Planning Application Ref: M/80/19/PL

Location: Former Poultry Farm, Land West of Yapton Road, Middleton on Sea, PO22 6DY

Description of works: Demolition of the existing structures & redevelopment to provide a new 66-bedroom care home (Use Class C2) arranged over two storeys together with associated access, car and cycle parking, structural landscaping and amenity space provision

Comments on Application:

Drawing no: PJC/5256/19/C	Rev: -	Sheet number: 1 of 4
Client and site: Edmonds Williams Ltd		
Yapton Road Middleton-on-Sea PO22 6SE		
Drawing title: Tree Protection Plan		
Date drawn: 28/08/2019		
Scale: 1:200 at A3		
Drawn by: LR	Checked by: PD

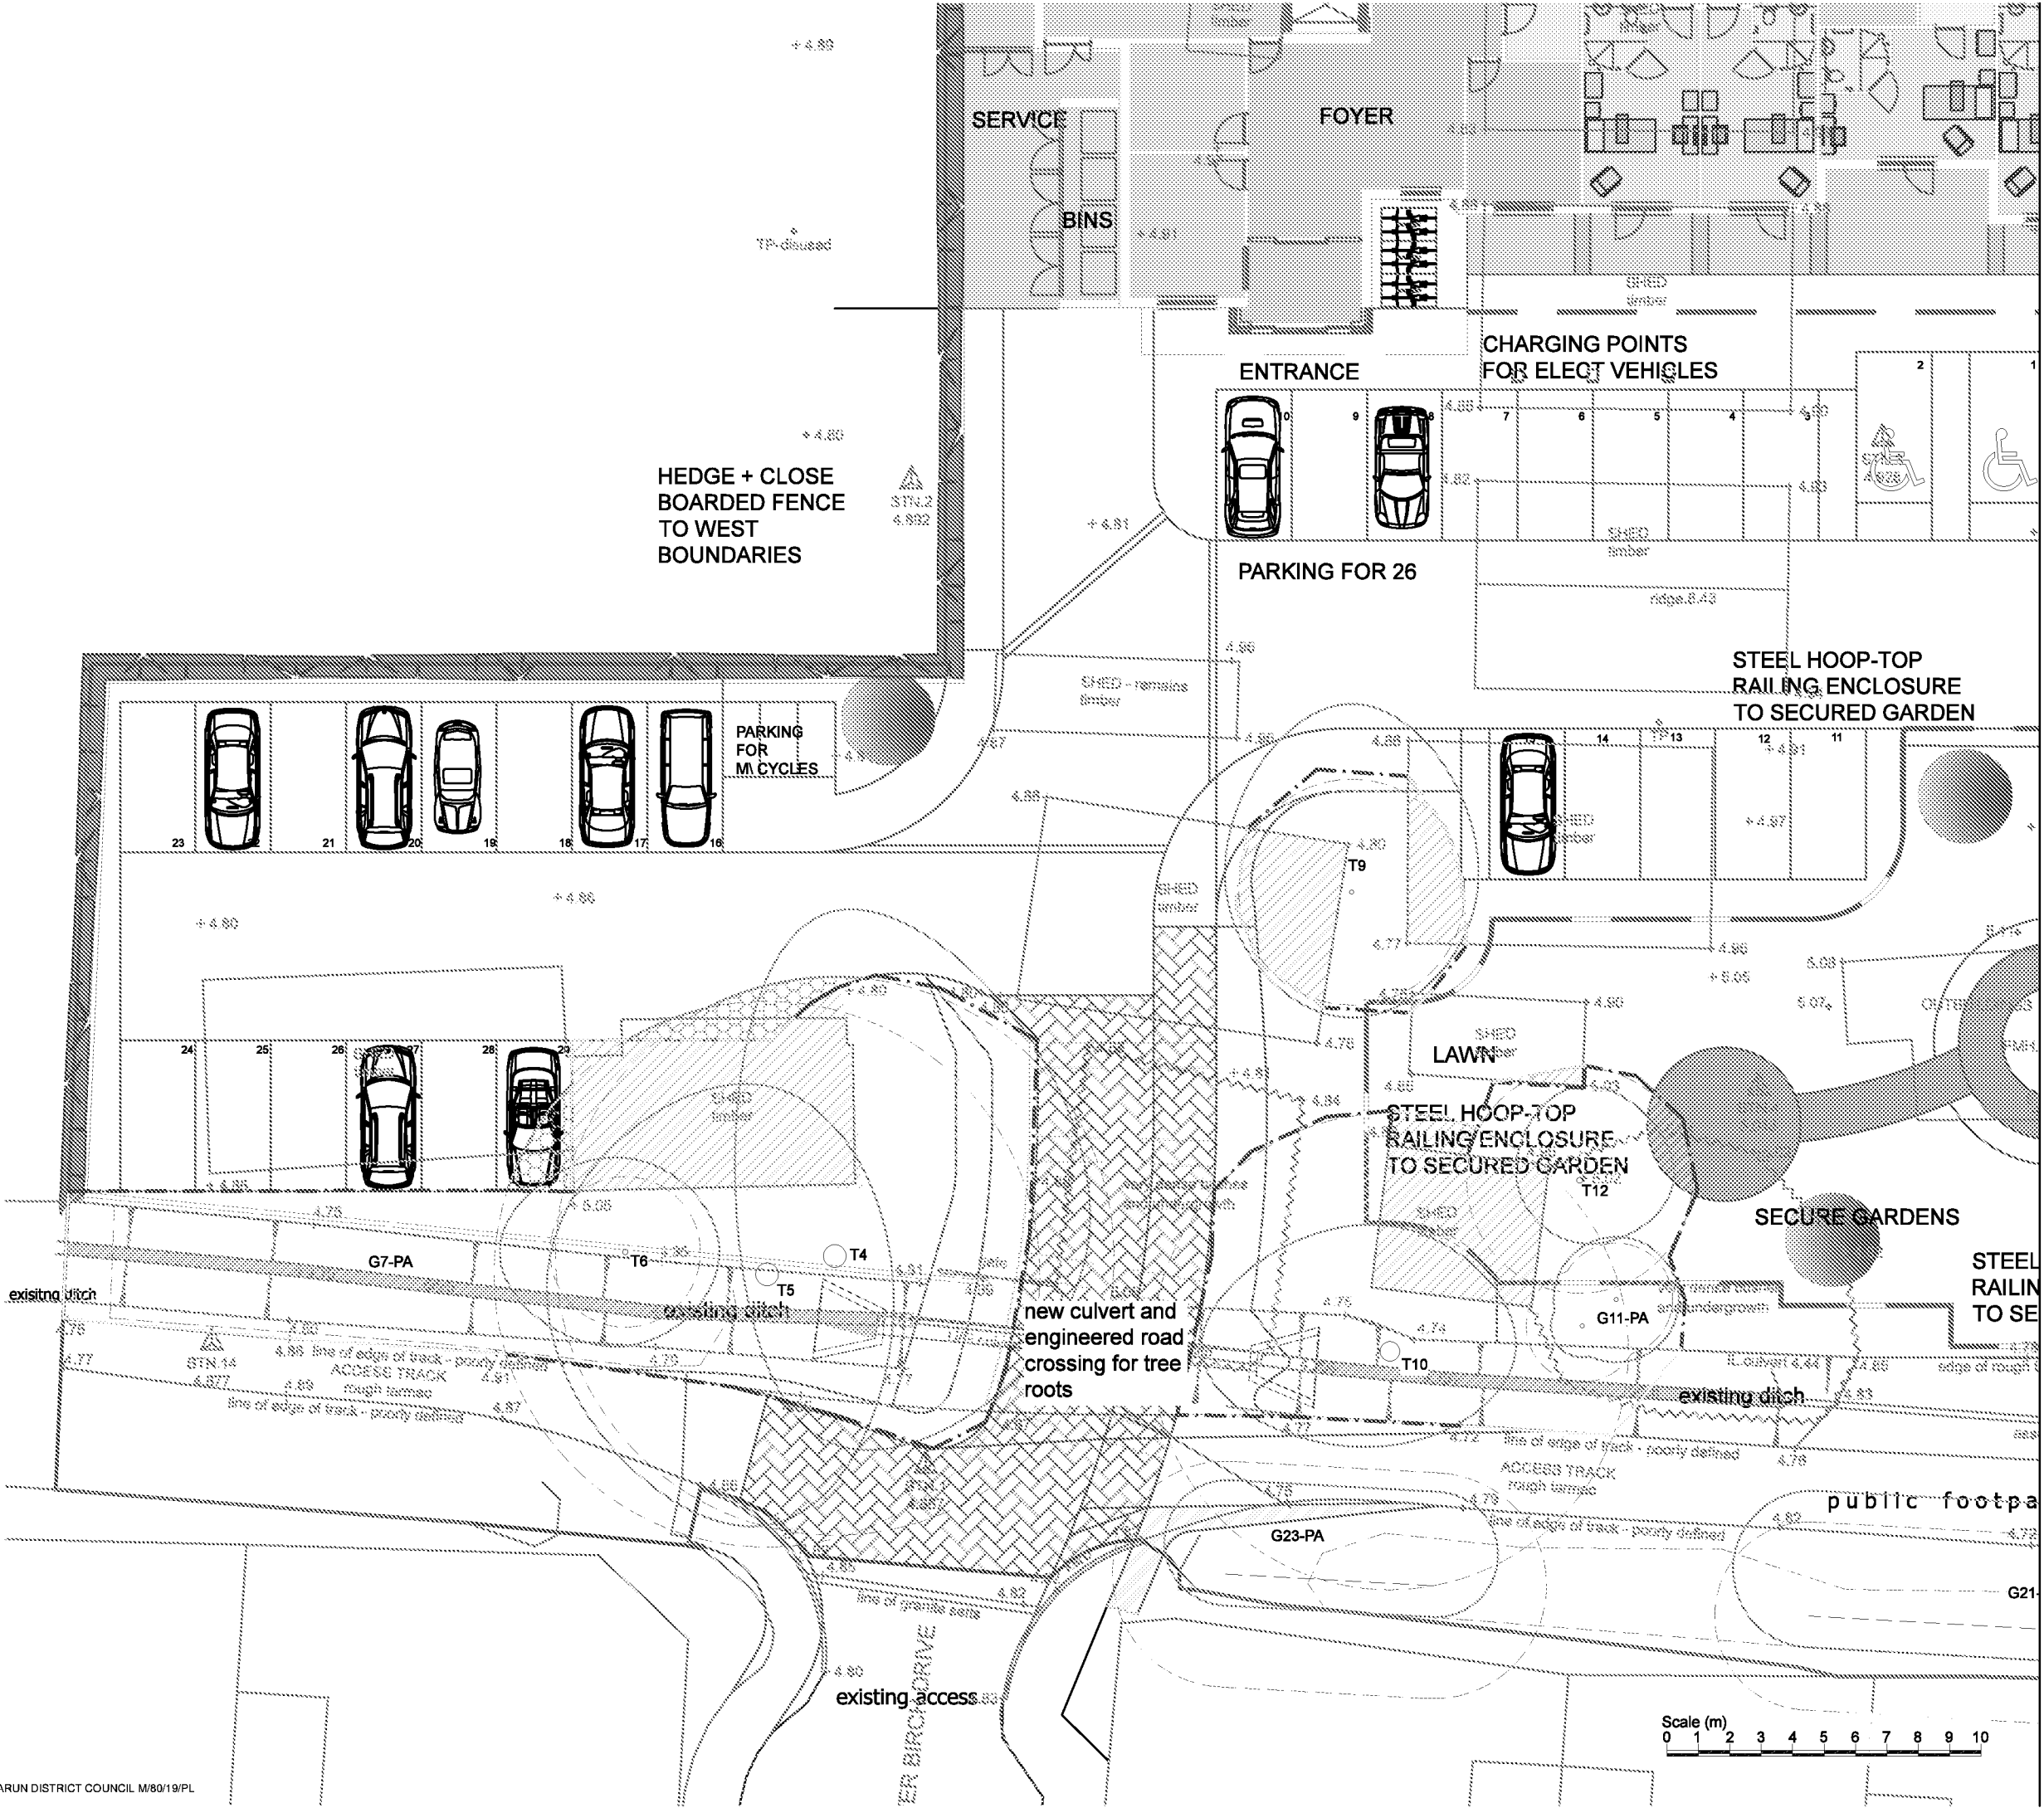
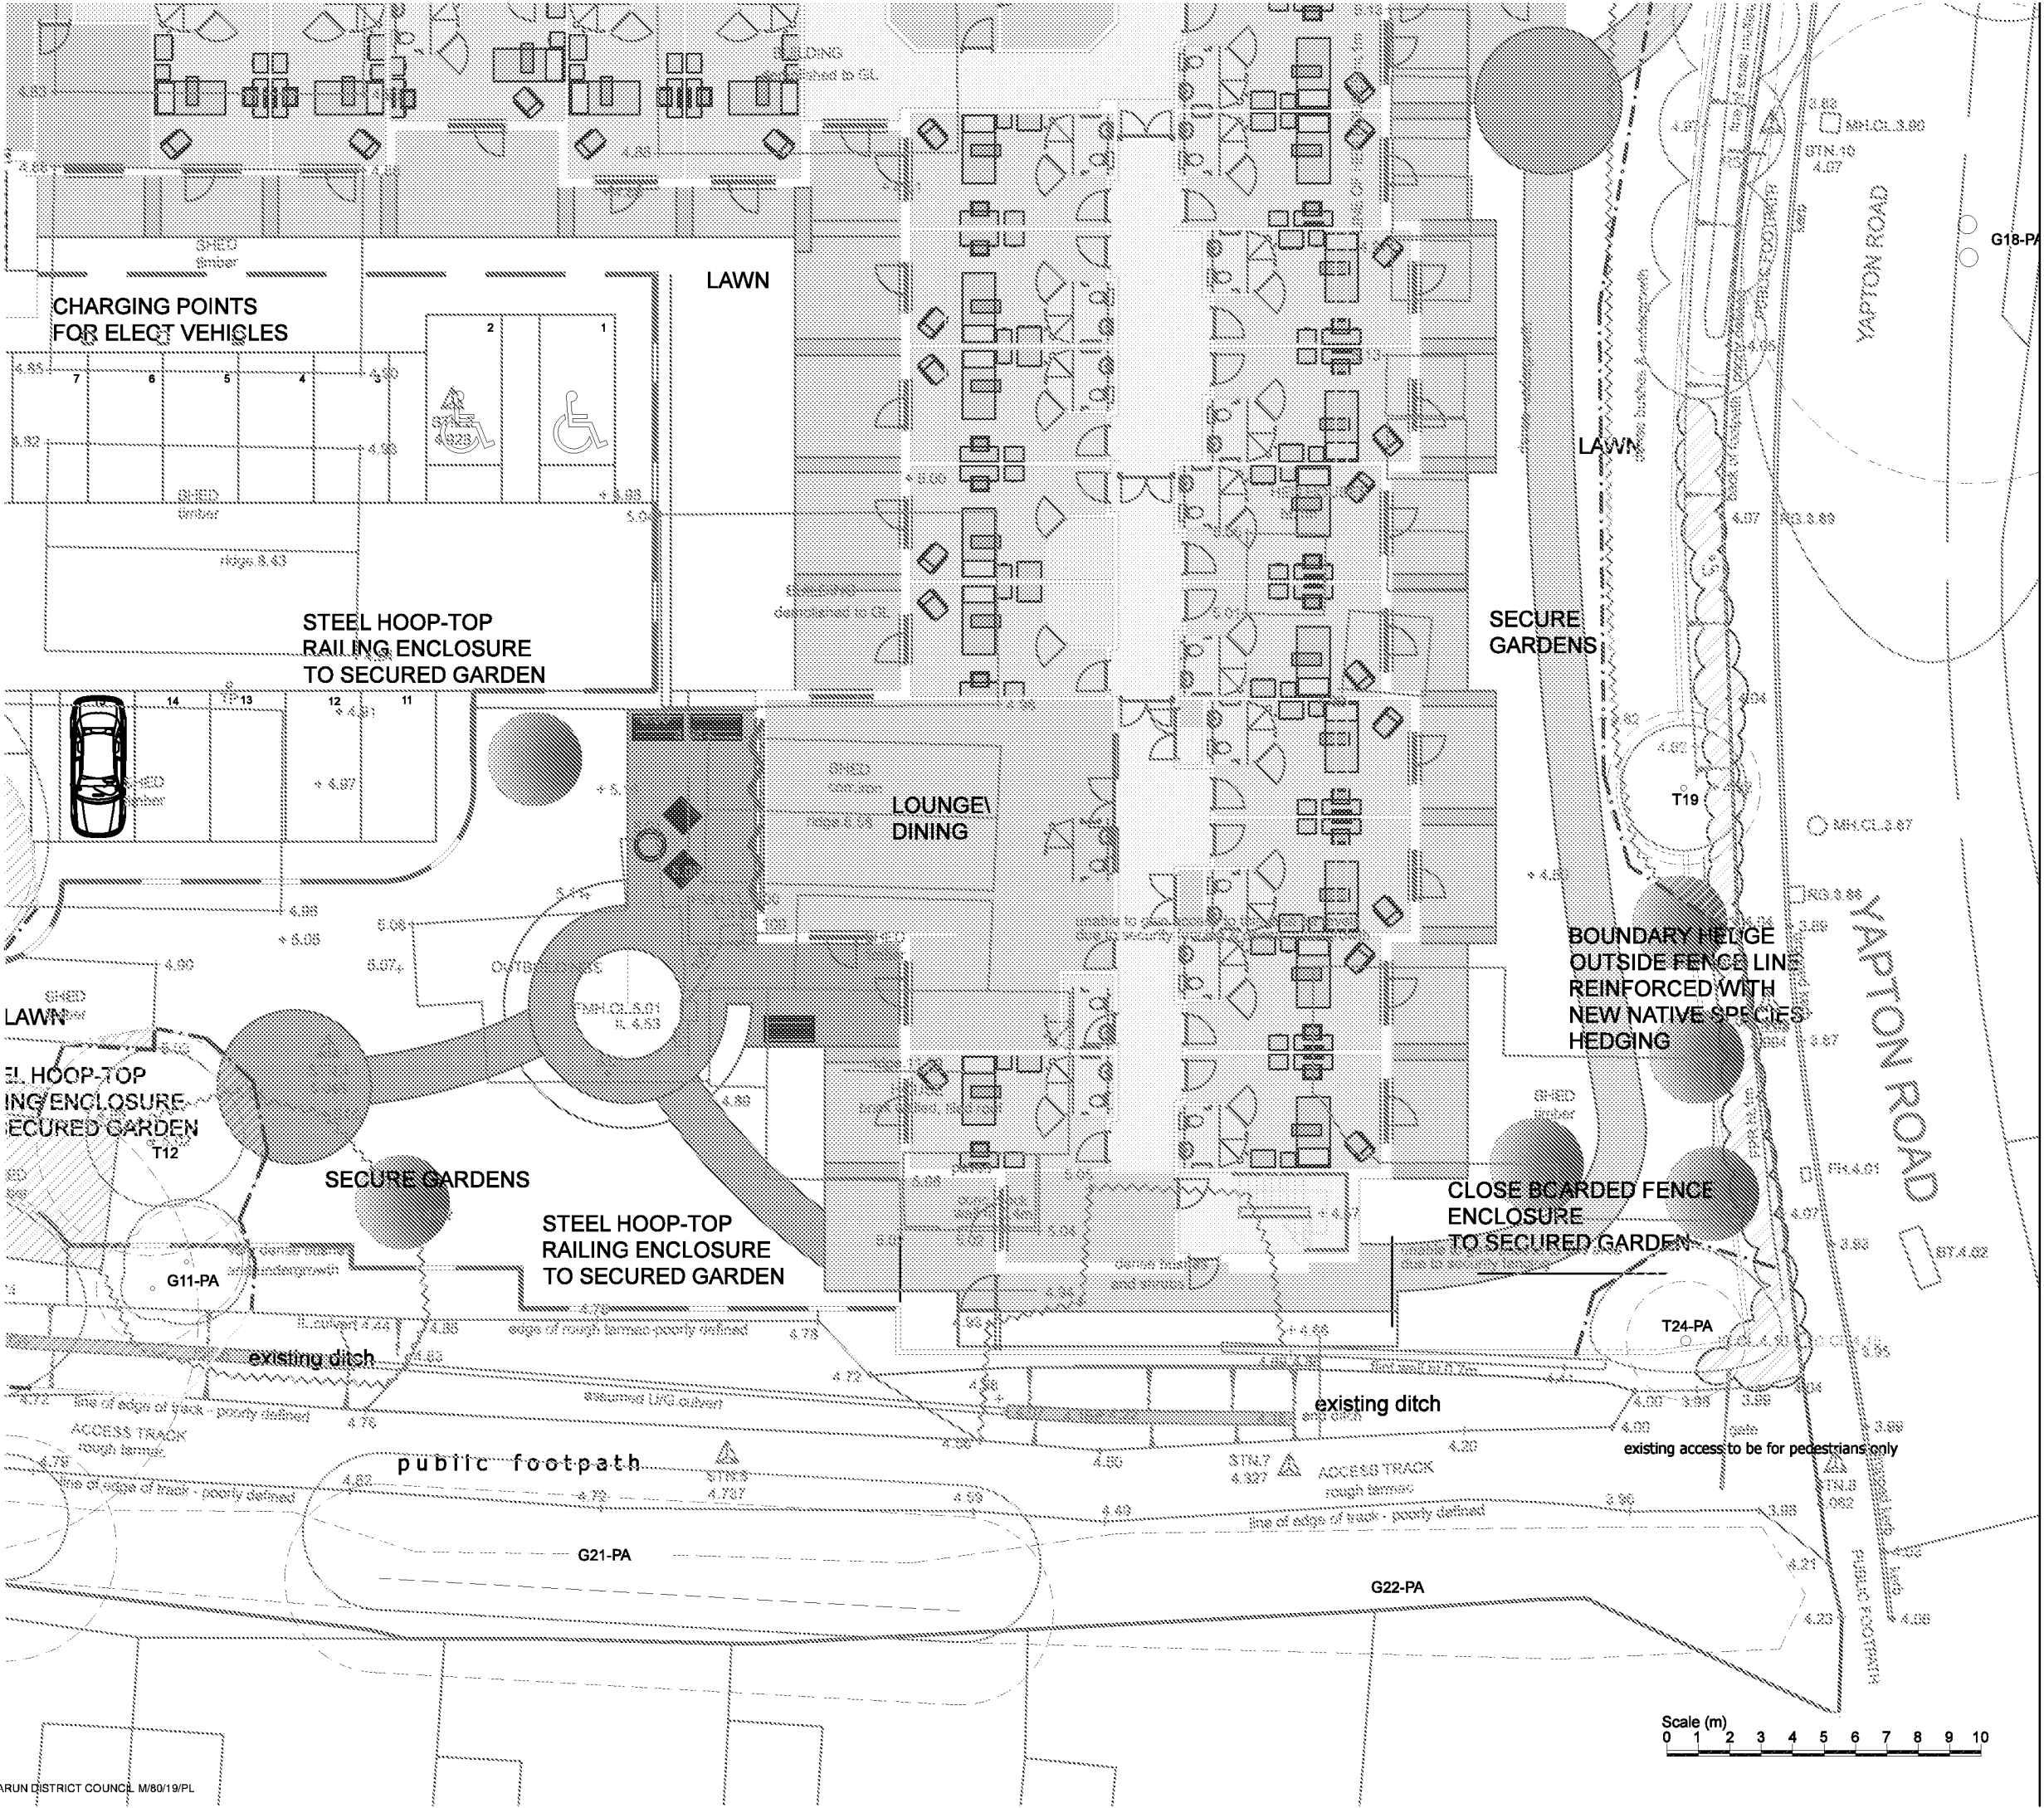
- If you are of a mind to approve this scheme as it stands, then I would recommend the following conditions be applied:
 1. Before the site is occupied or any machinery is introduced to the site or demolition work or construction work or alterations to existing ground levels takes place a **PRE-COMMENCEMENT Site Meeting** is to take place between the Planning Authority's Tree Officer and the Arboricultural Expert representing the site owner(s) – at this meeting all protective fencing and ground protection measures will be inspected to verify they are 'Fit for Purpose' as required under British Standard 5837:2012 and have been erected and positioned exactly as shown on the **Tree Protection Plan, PJC/5256/19/C (sheets 1 to 4), 28/08/2019.**
